SSD-94006708 RESPONSE TO SUBMISSIONS COVER LETTER
PROPERTY AT 15-21 Cottonwood Crescent

Re: 88 Waterloo Road, Macquarie Park NSW

Specifically, this letter provides an overview of the amendments made to Appendix N Landscape Design Report and Drawings in response to the DPHI request for additional information on 25th May 2026 and relevant agency comments.

Table 1 – Response to Agency Comments DPHI Key Issues

● LANDSCAPE SECTION ELOUERA RESERVE INTERFACE: SECTION DD + EE

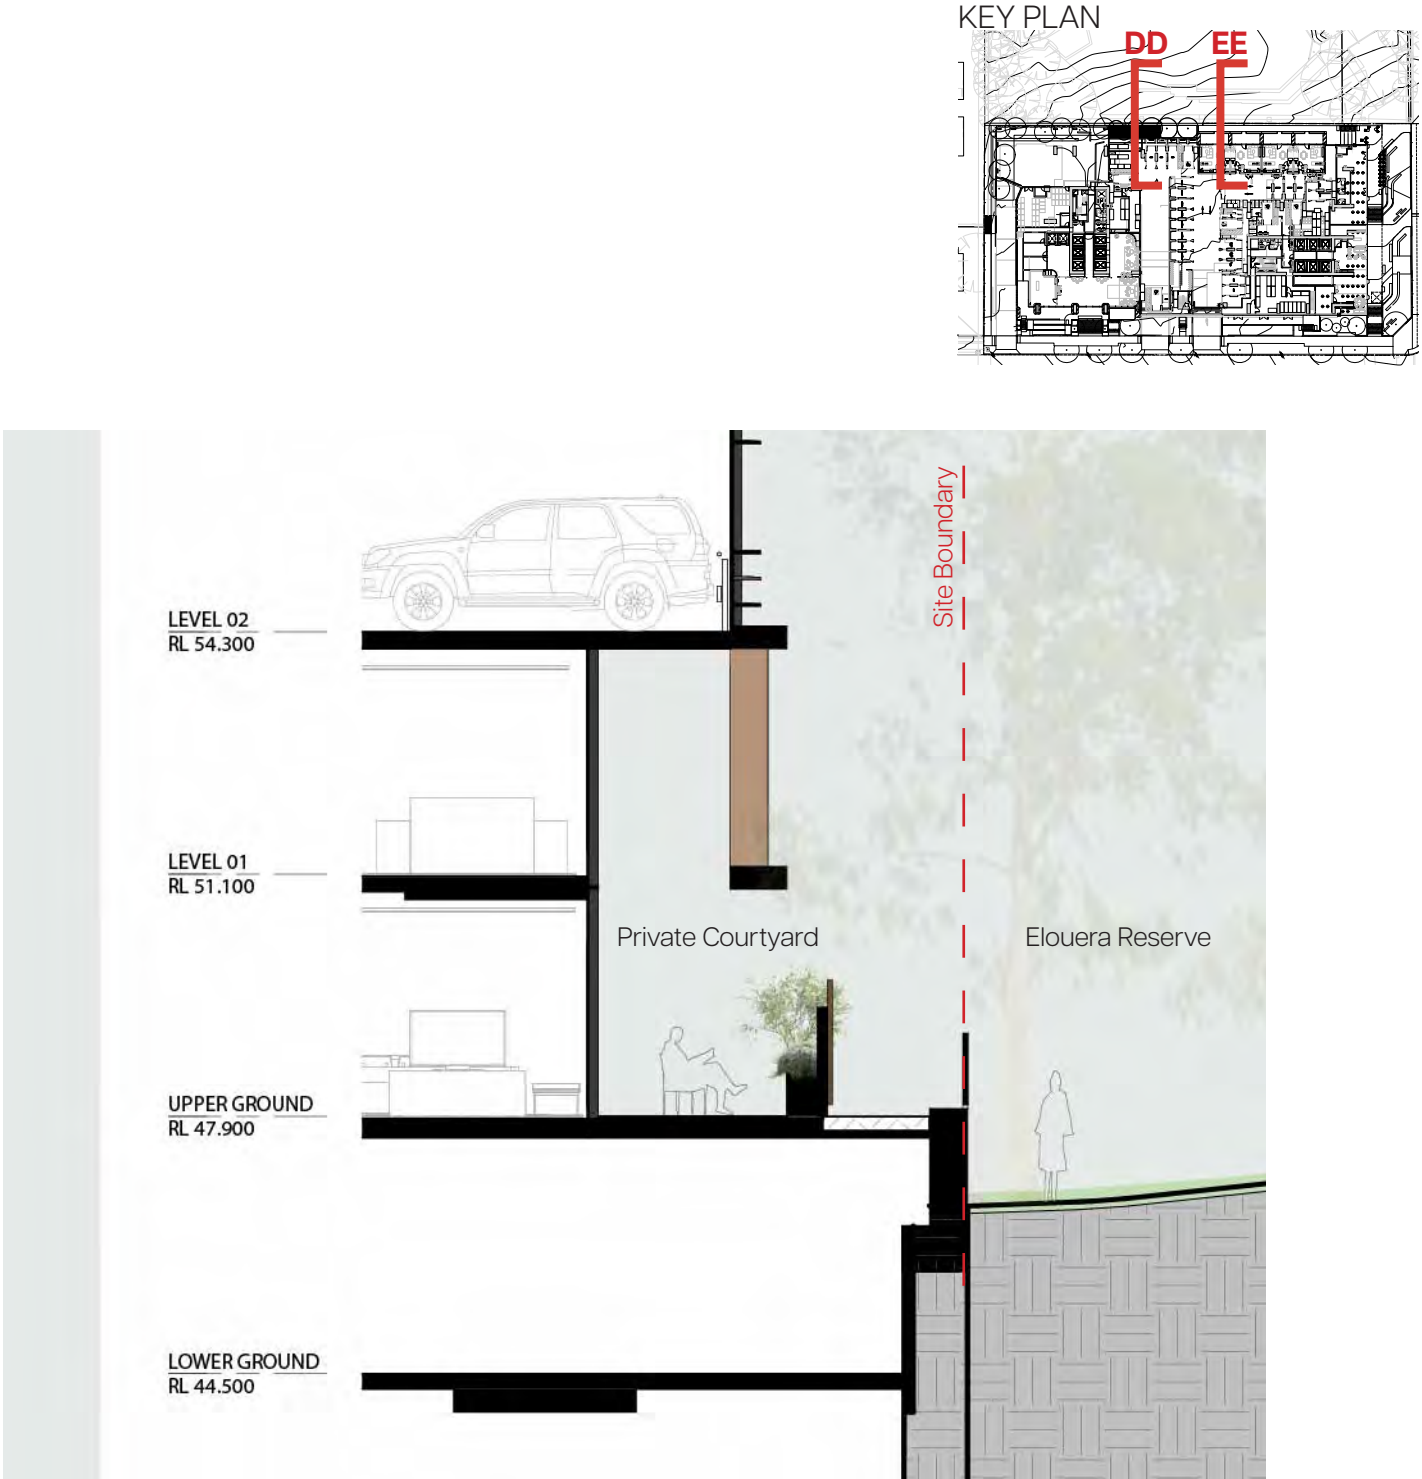
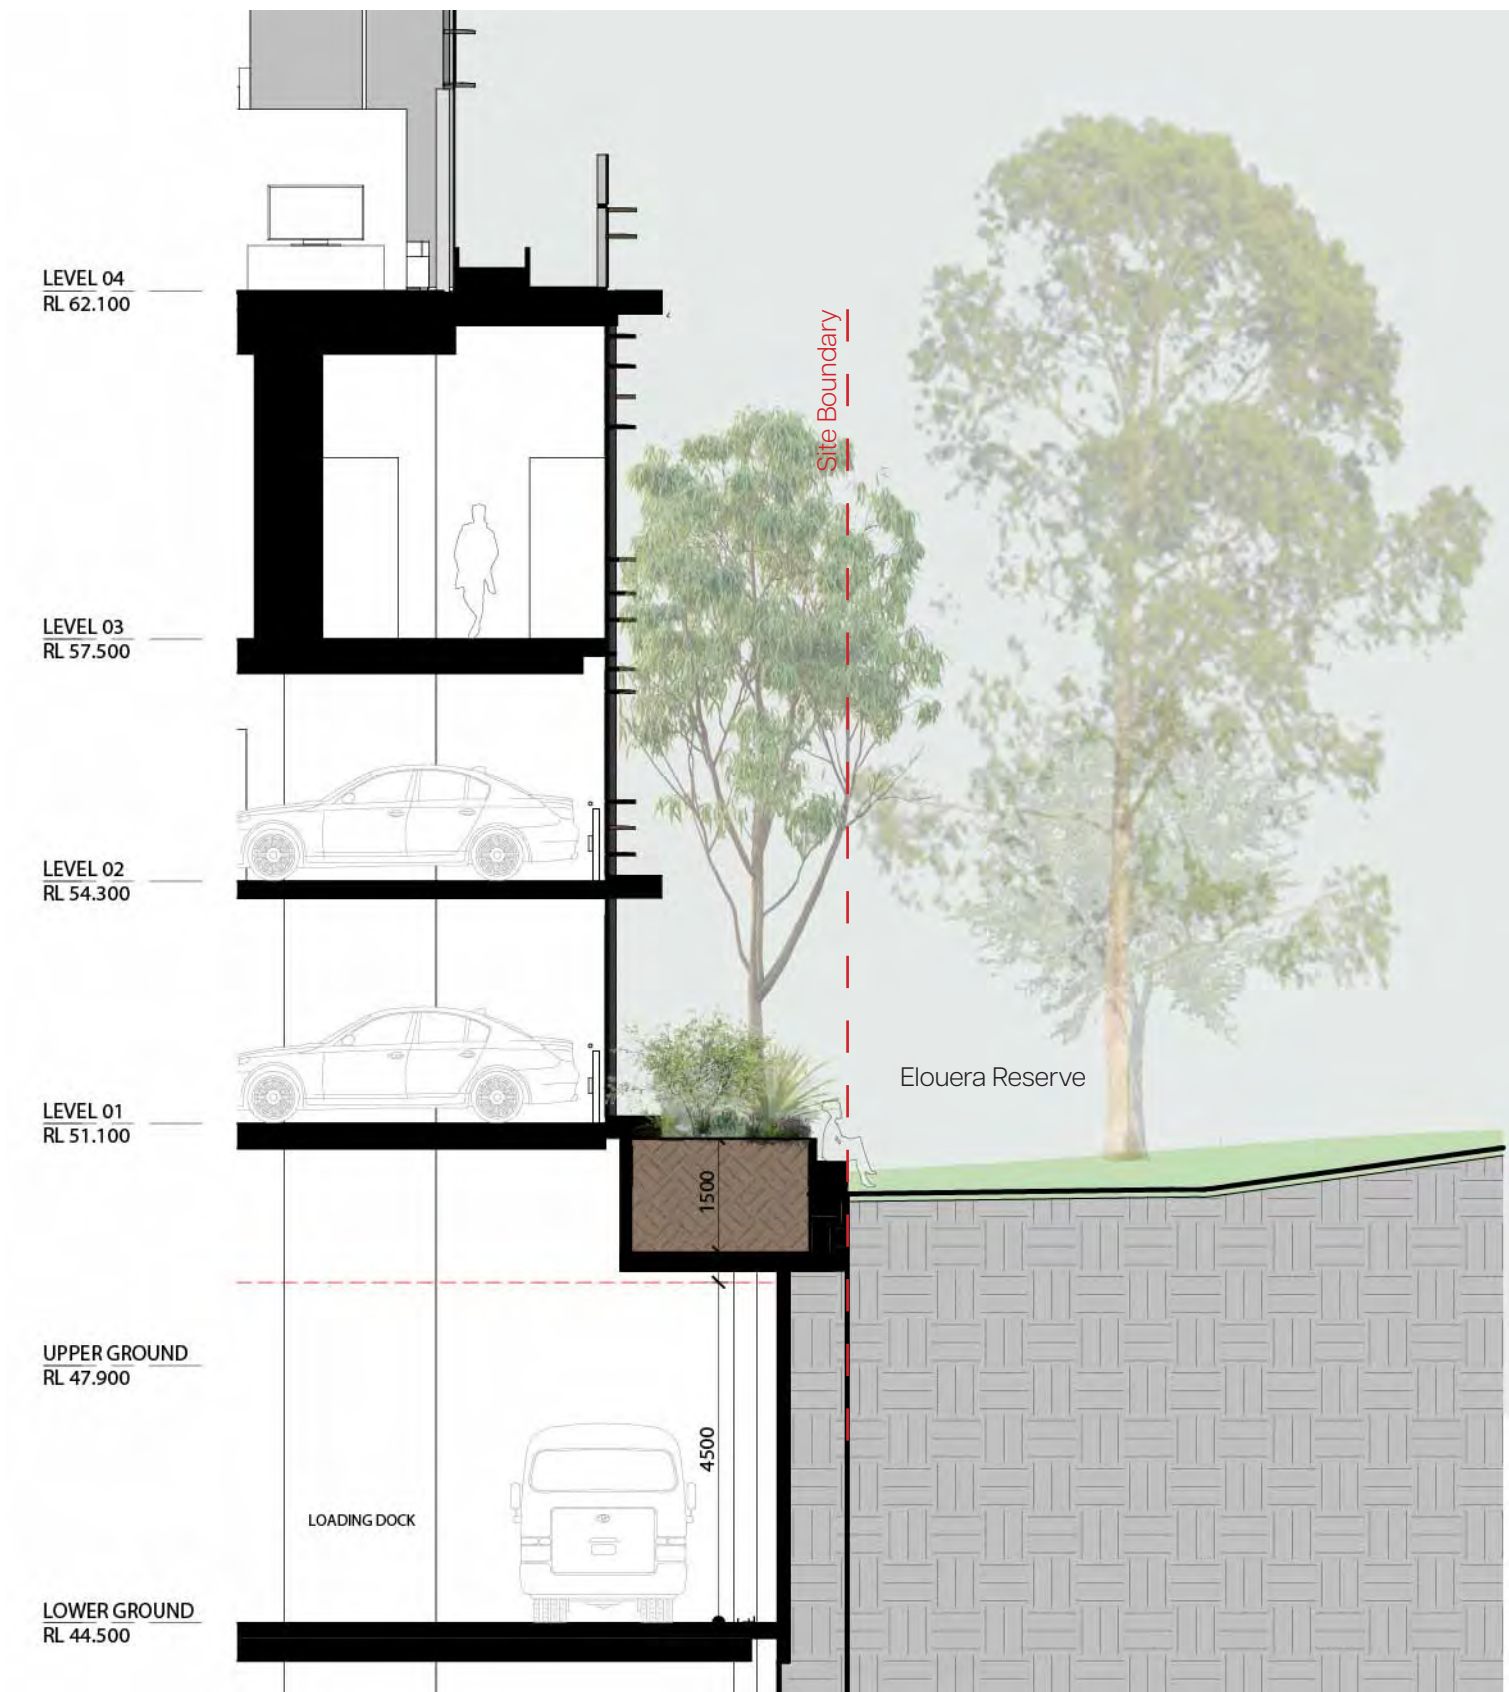
C	Design Quality: The proposal's podium interface with Elouera Reserve is suboptimal due to limited setbacks and four levels of car park screening across approximately half of the	The podium setback to Elouera Reserve has been increased in localised areas to retain tree T41 along the boundary. To offset the visual bulk of the podium,

frontage. While three trees are proposed along this boundary to offset the visual bulk of the podium, their establishment and growth would be constrained by the podium two storeys above and basement parking below. The podium setback to Elouera Reserve must be increased to facilitate tree retention, additional tree planting, improved building interface and reduce perceived bulk.

extend areas of planting suitable for tree planting with 1.5m soil depth have been increased and an additional 10 trees have been added along the Elouera Reserve interface to assist in screening the car parking.

Additional elevations have been provided from Elouera Reserve to demonstrate the increased landscape zones achieved.

Refer Elourea Reserve Sections DD, EE, FF – Page 36 – 37 of Design Report

● ACCESSIBILITY LANDSCAPE MASTERPLAN

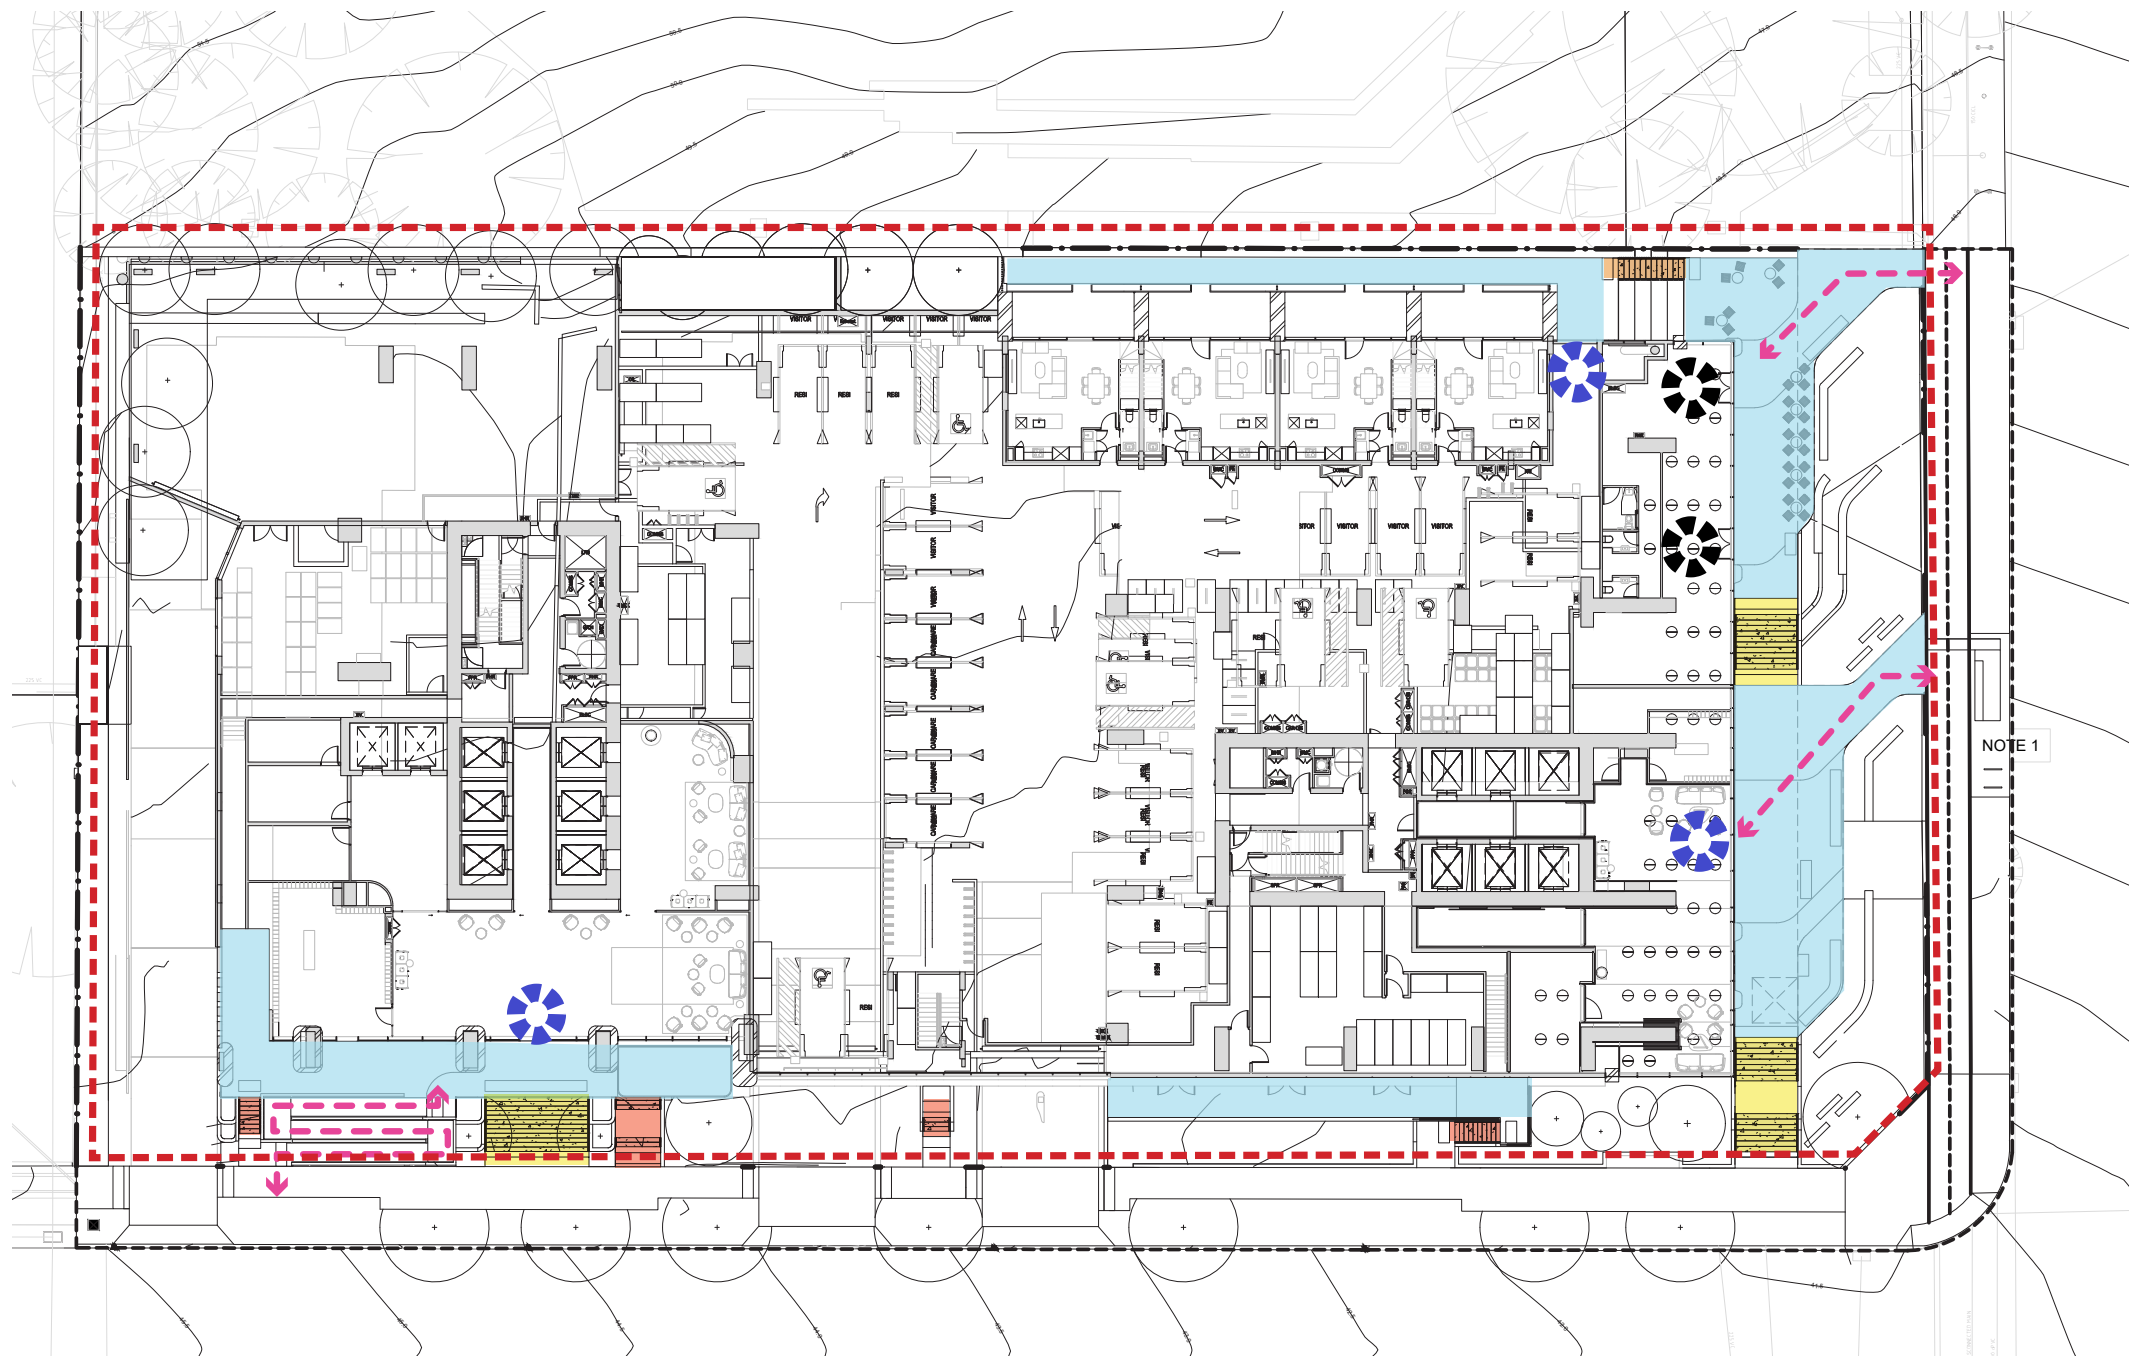
The accessible entry to the Waterloo Tower lobby is through an informal decked seating area. This does not present as a clear and legible main building entry. The design and location of accessibility points to main residential lobbies must be prioritised to establish a clear and publicly accessible street interface.

The re-design of the Waterloo Road interface to accommodate the changes to the retail provide accessible entry points which present as a clear and legible main building entry connecting to the publicly accessible street interface.

This is achieved through simplified wide pathways following the direction of travel along paved footpaths, supported on root bridge systems for areas within the existing tree TPZ zones.

Refer Accessibility Plan – Page 44 of Design Report ● ACCESSIBILITY LANDSCAPE MASTERPLAN LEGEND - Site Boundary - Level Access - Stairs - Accessible Routes to Entrances - Residential Entrance - Detail Entrance 
E	Design Quality: The submitted elevation drawings do not sufficiently detail the proposal's design response to streetscape, context and public domain.	Please refer to landscape elevations for streetscape and public domain along Waterloo Road and Cottonwood Crescent frontage.	Refer Elevation CC – Waterloo Road – Page 32 of Design Report
